CITY OF ALBUQUERQUE

**Planning Department
Transportation Development Services Section**

Re: Certification Submittal for Final Building Certificate of Occupancy for
Padilla Marble, [M-10 / D16E]
6901 Huseman Place SW
Architect's Stamp Dated 05/08/08

**Re: Padilla's Marble, 6901 Huseman Place NW, Traffic Circulation Layout
Architect's Stamp dated 8-14-06 (M10-D16E)**

SITE PLAN
SCALE: 1"=20'

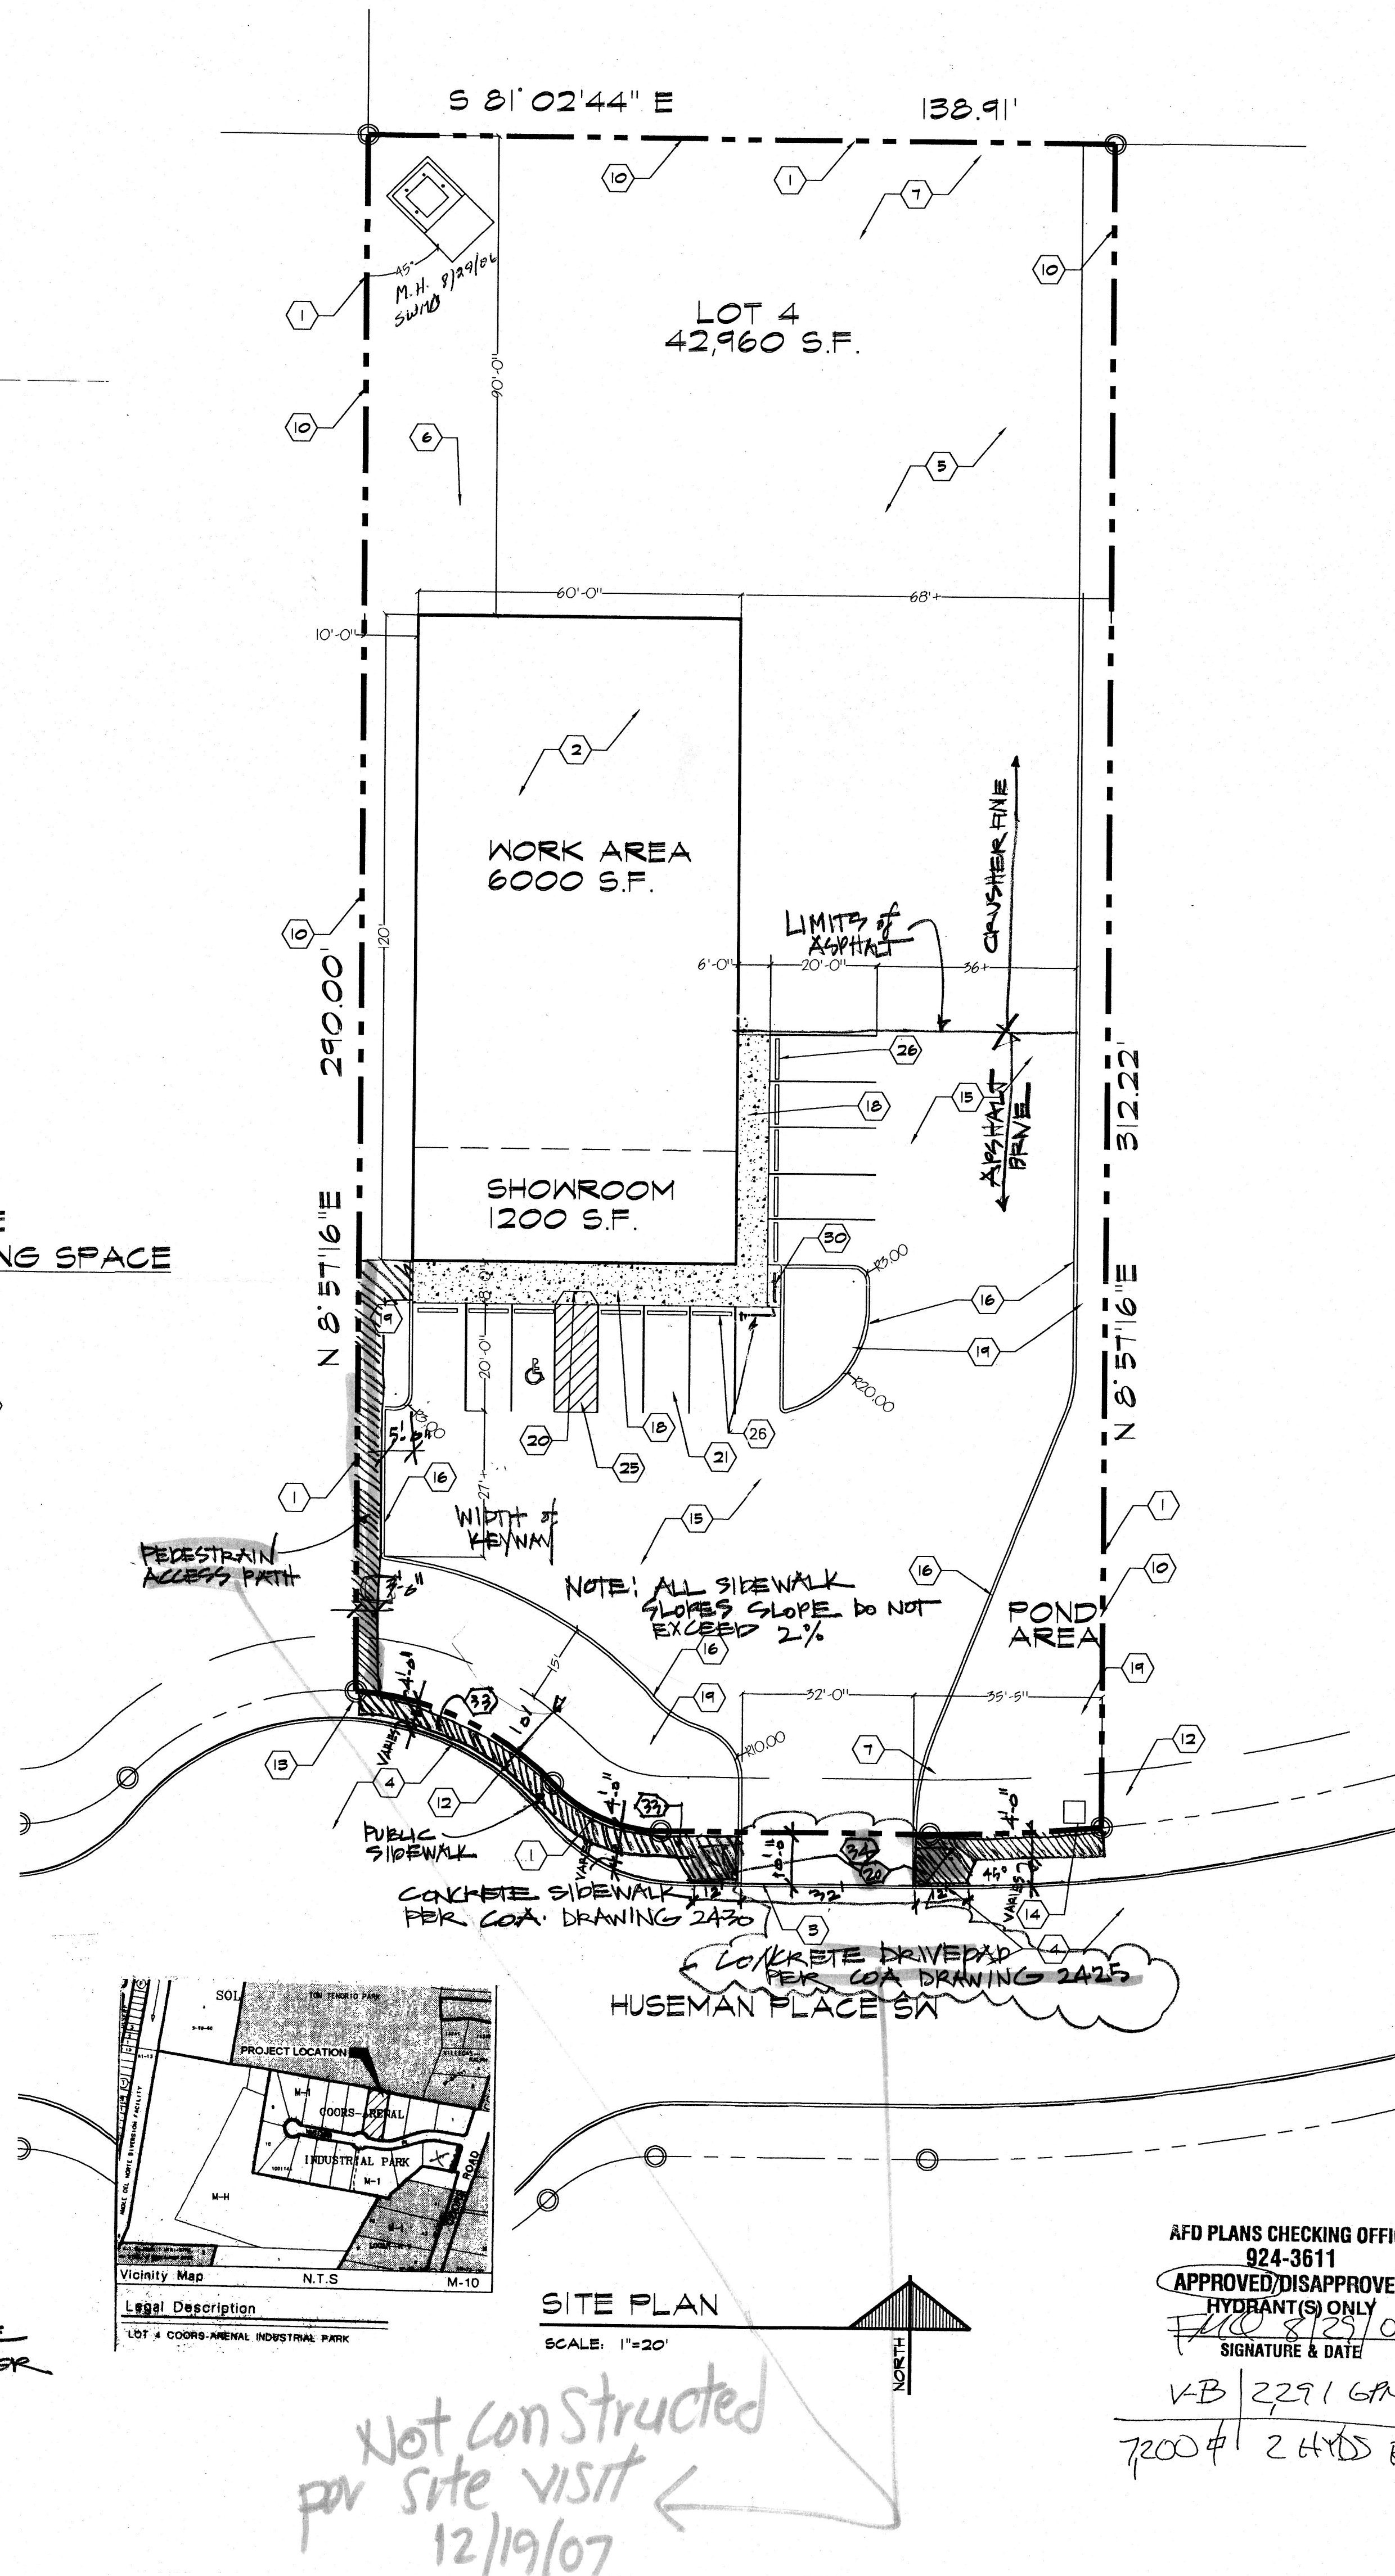
An extension of the temporary C.O. has been issued allowing the driveway entrance modification (to provide ADA access path across entrance) issues to be completed within this time period. When these remaining issues have been fully completed, are in substantial compliance, and a final Certification for Transportation has been resubmitted to the City's Hydrology office for approval, a Permanent C.O. will be issued.

A Temporary C.O. has been issued allowing the outstanding driveway entrance (not built per plans which call out 12:1 ramps for ADA) and pedestrian access path onto site (not constructed) issues to be completed within this time period. When these remaining issues have been fully completed, are in substantial compliance, and a final Certification for Transportation has been resubmitted to the City's Hydrology office for approval, a Permanent C.O. will be issued.

6 CURB RAMP
NTS

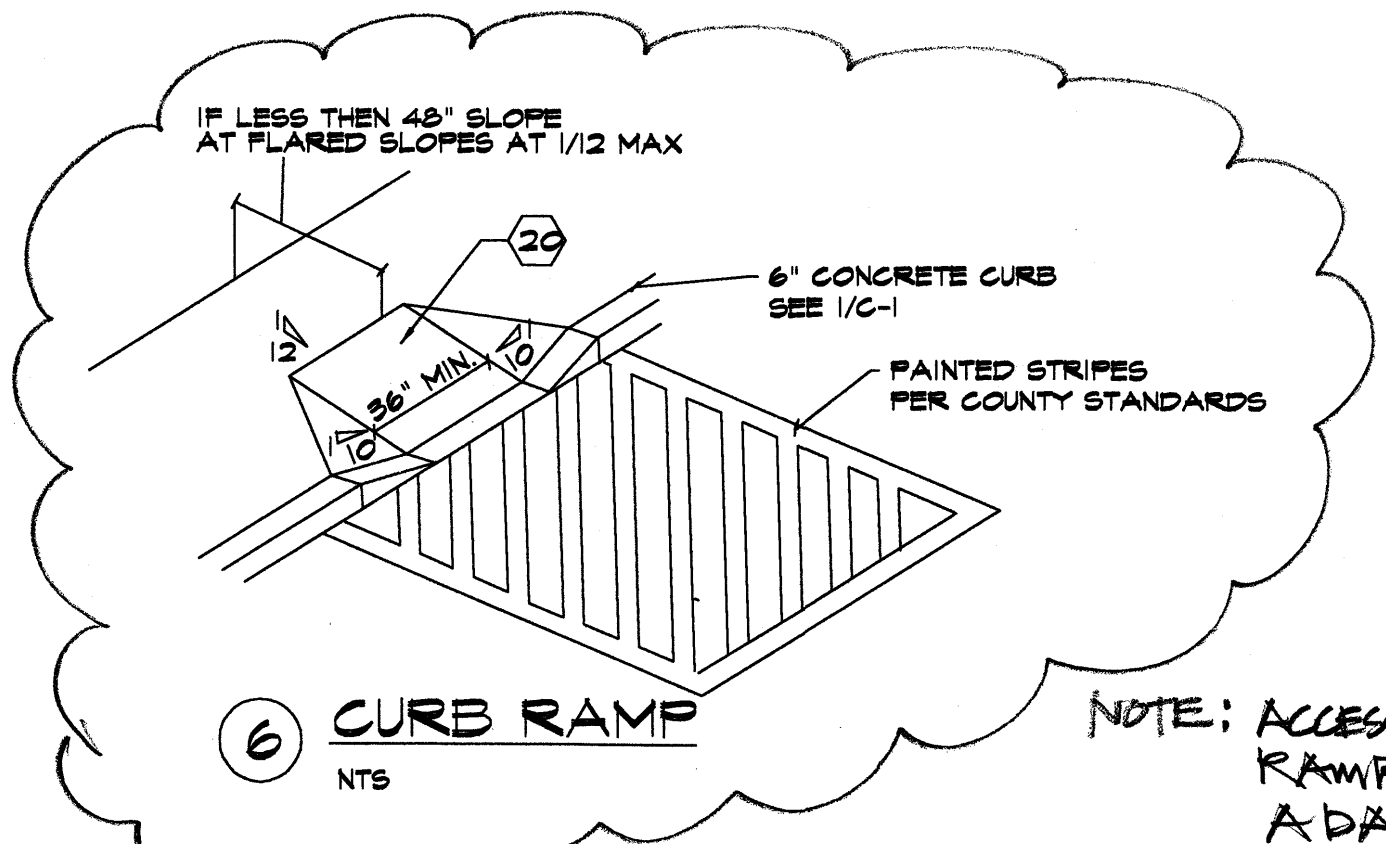
Ramp detail provided does not meet current ADA
standards - refer to City Std

8. Place proposed sidewalk at the property line.
9. Ensure all ramps are ADA compliant.
10. Show a detail of the wheelchair ramps located at the proposed driveway, or refer to the appropriate city standard.

SITE PLAN
SCALE: 1"=20'

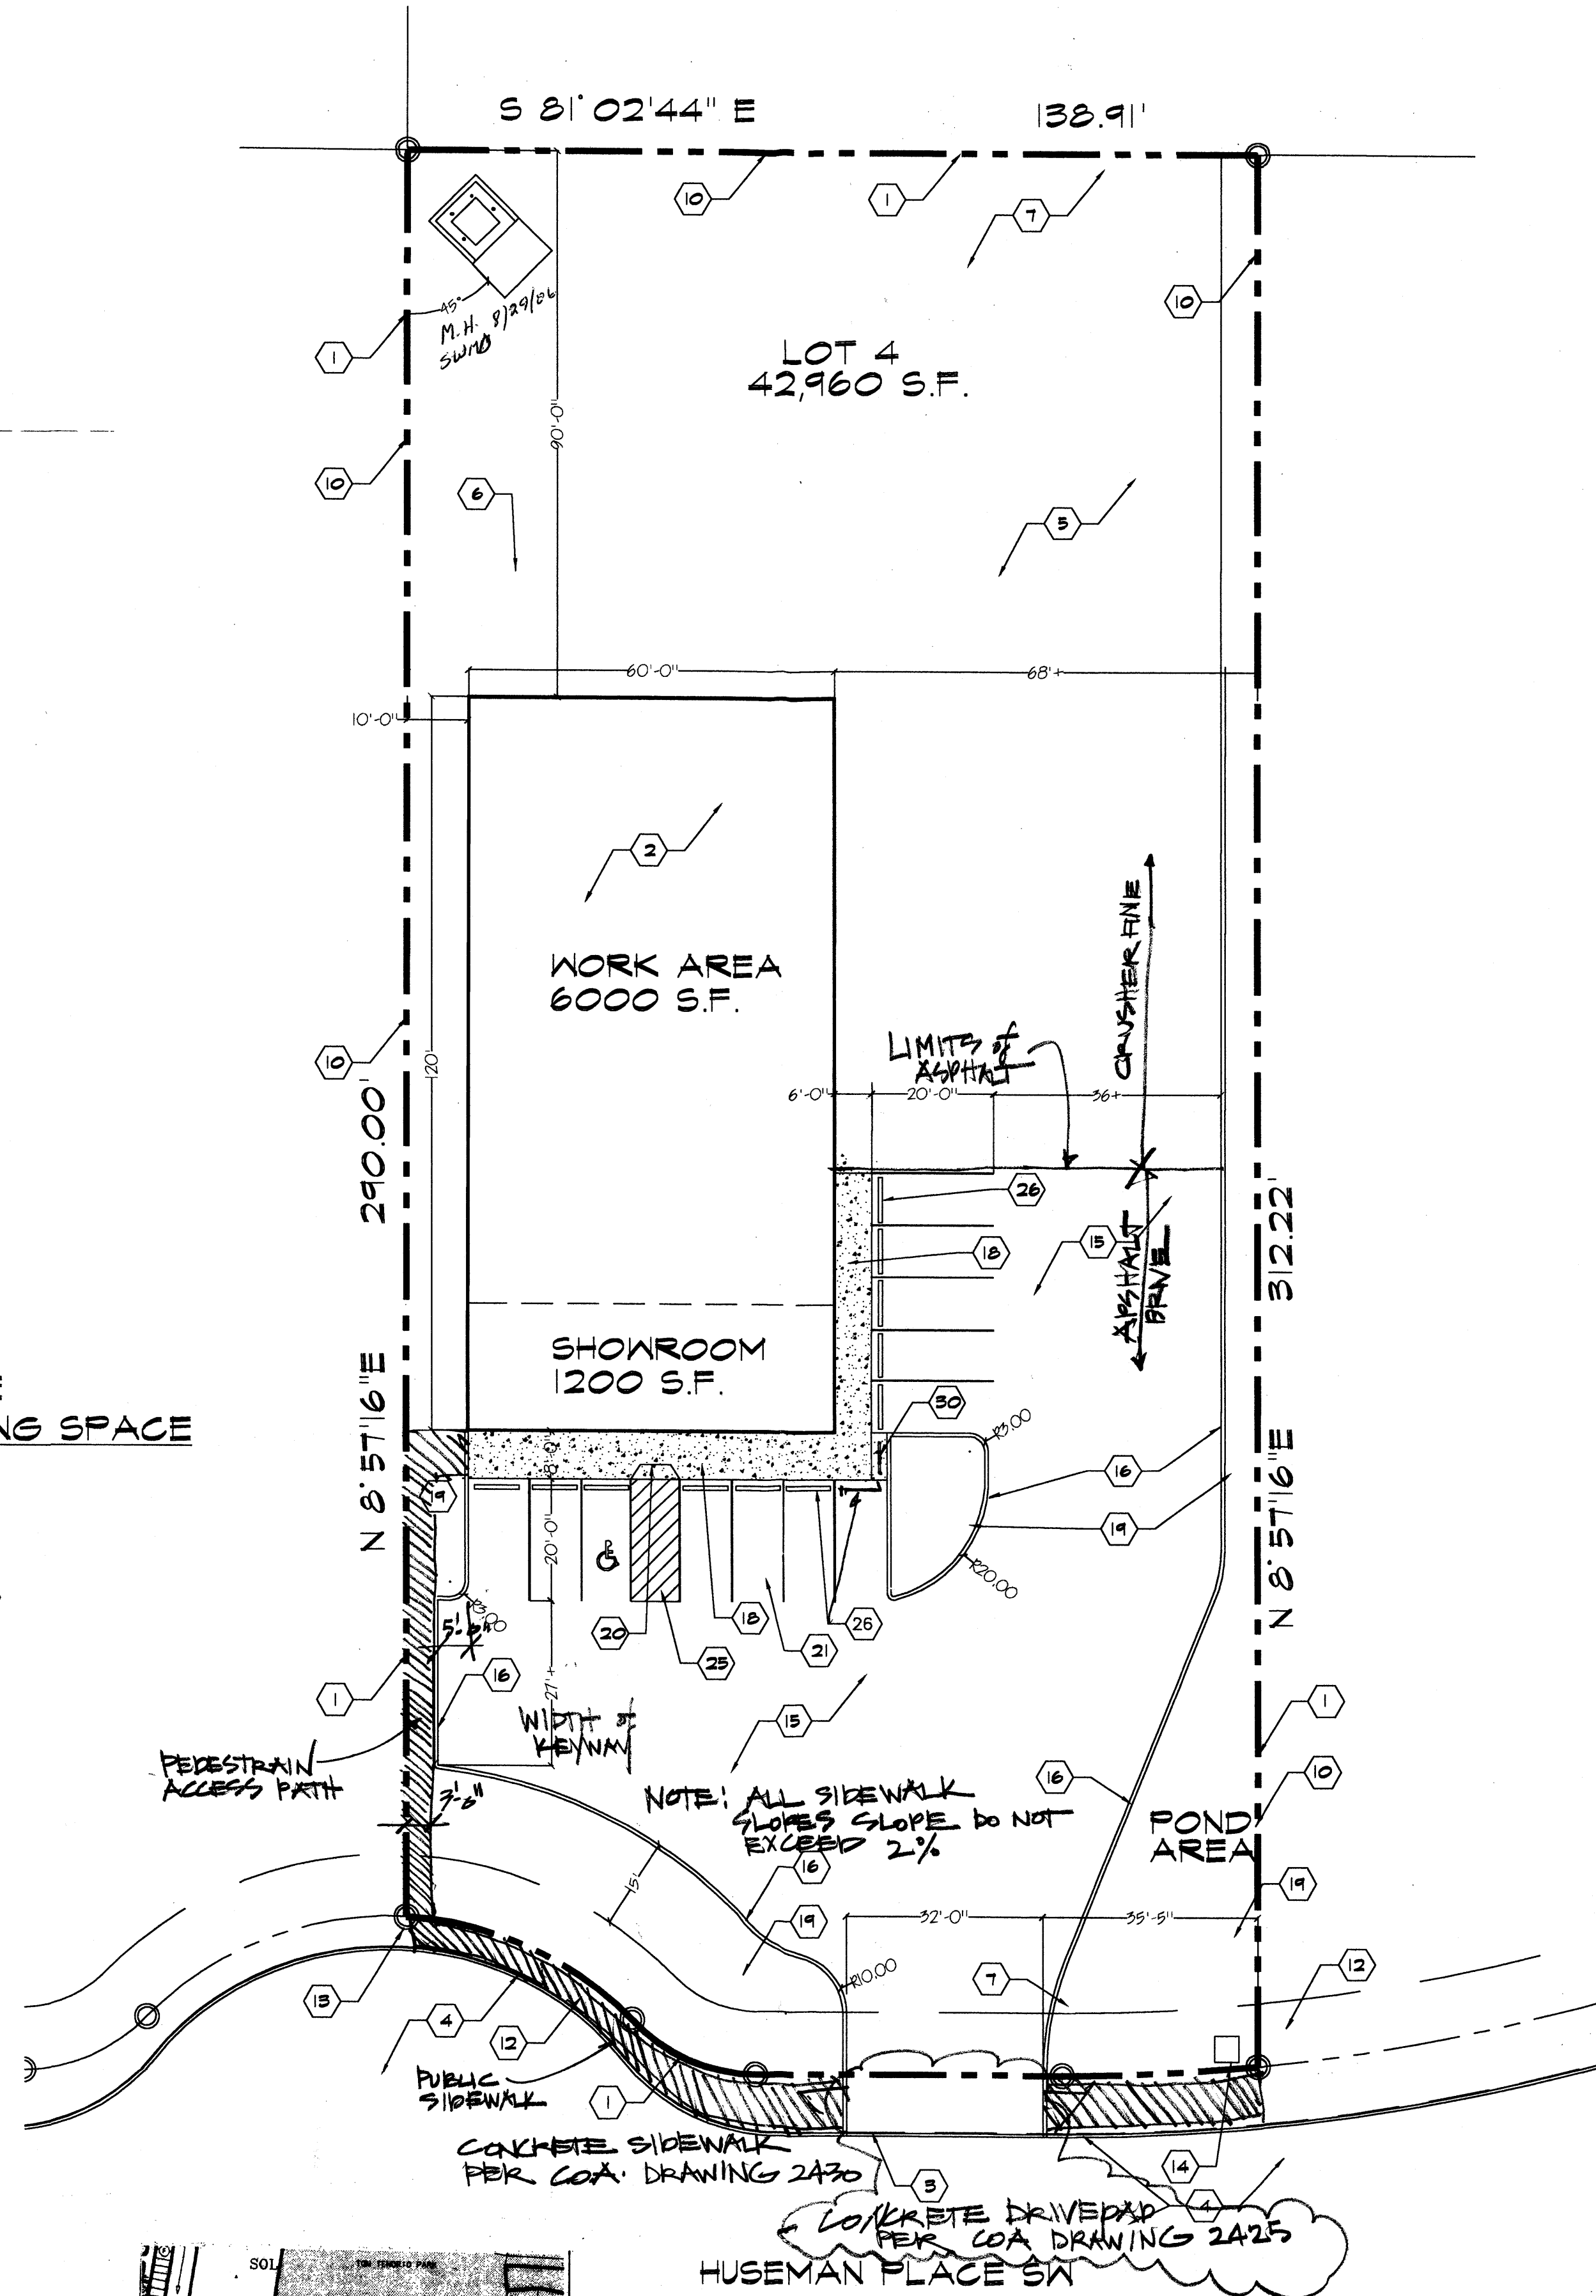
1. Provide a concrete sidewalk at the property line along Huseman Place. The sidewalk must be a minimum of 4 feet in width. Note all areas where the width of sidewalk changes.
2. Refer to the curb ramp detail in keyed note 20.
3. Provide a build note for the proposed drivepad, including the following information: remove existing curb and gutter; build 1-32' wide drivepad per City of Albuquerque Standard 2425; and build 2-unidirectional wheelchair ramps per City of Albuquerque Standard 2426 – maximum slope of 1:12.

Minimum 4' conc sidewalk at the property line
along Huseman Place

- call out proposed width(s) - note any changes with changes

Build Note: Remove existing curb and gutter; Build 1-32' wide

driveway per CoA Std 2425

Need 2 of the following build notes:

Build 1 - unidirectional wheel chair ramp per
CoA Std 2426 - max slope of 1:12

At driveway

or provide

ramp detail
at driveway

1. Call out the width of the keyway shown in the southwest corner of the site.
2. Please show a vicinity map.
3. Show the limits of the proposed asphalt.

4. Why does one of the proposed parking spaces lack a concrete parking bumper?
5. To accommodate ADA standards, all driveways must have a 3-foot wide pedestrian access path. This path must have a cross slope no greater than 2%.

6. Add a note to remove the existing curb and gutter and a build note, referring to all appropriate City Standards, to the proposed driveway.
7. The handicapped spaces must be a minimum of 8.5 feet in width.
